2023_25/PL
09th November 2023

Re: 27 Pickford Road, Bexleyheath DA7 4AG

Please find enclosed copies of the drawings; together with completed applications forms comprising of a householder planning application at the above site.

drawing title	Revision
Proposed Elevations PLANNING DRAWINGS	A

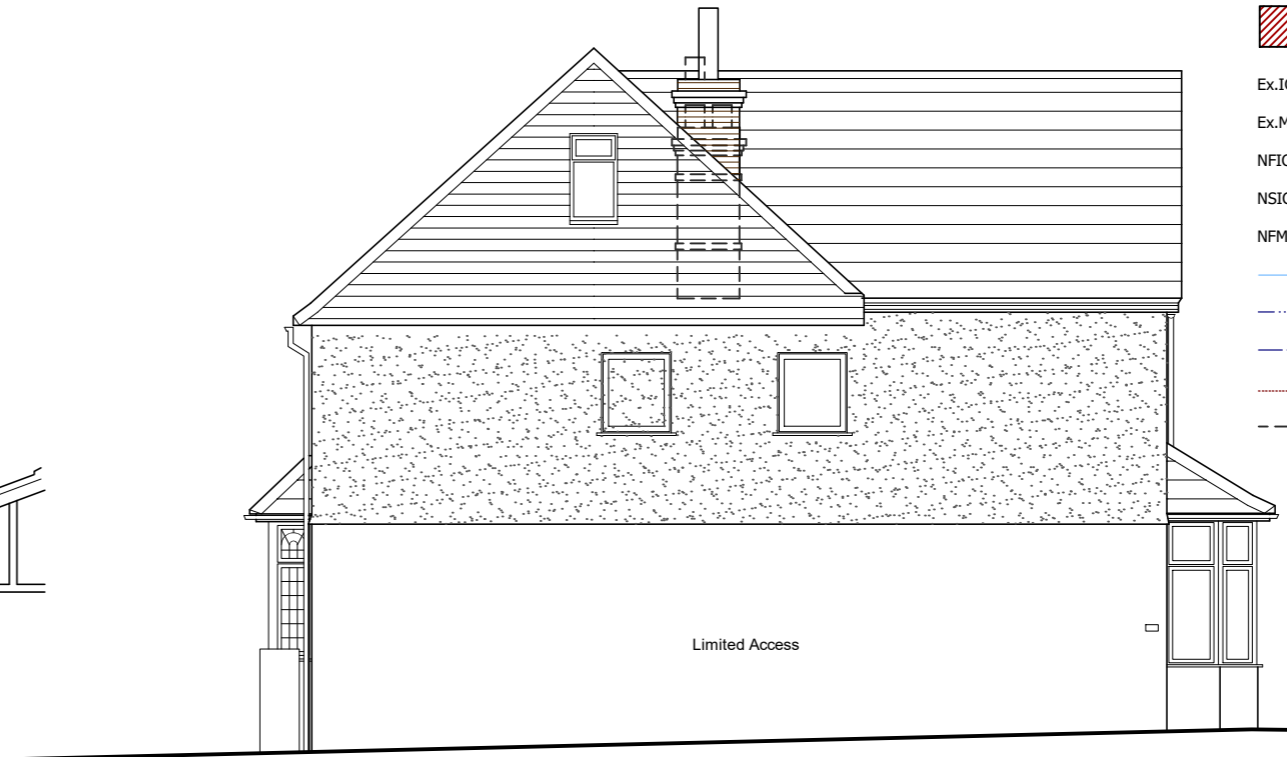
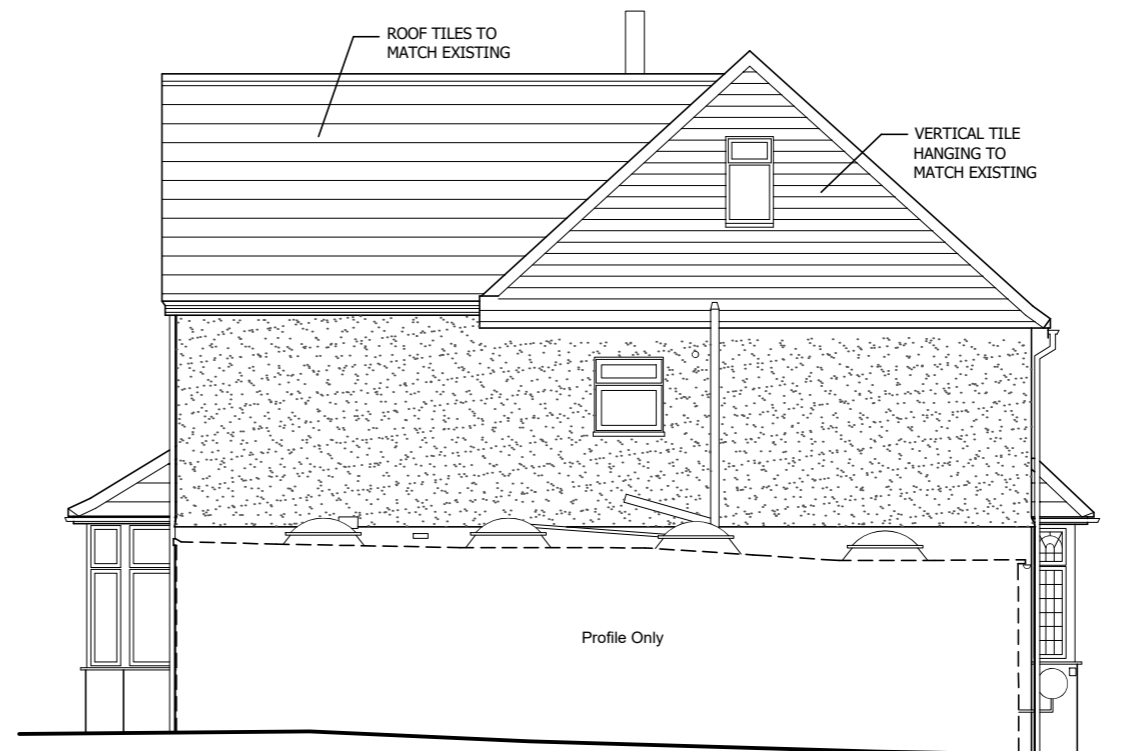
Prior to submitting this application, a pre-application enquiry was submitted, reference number 23/02487/PREAPP. The summary of that process was, the proposal is considered acceptable subject to minor changes. We have reviewed the officers' comments, which were, increase set-down of the rear additional roof to 300mm. They also asked us to look at the eaves mismatch, to see if this could be minimised.

The design has been amended to show a 300mm step down from the main roof the proposed rear roof. Looking at the eaves it would be difficult to reduce the height because the head space within the proposed loft area, however by extending the soffits the eave line has been lowered by 75mm which will help minimise the slight level change in the eaves.
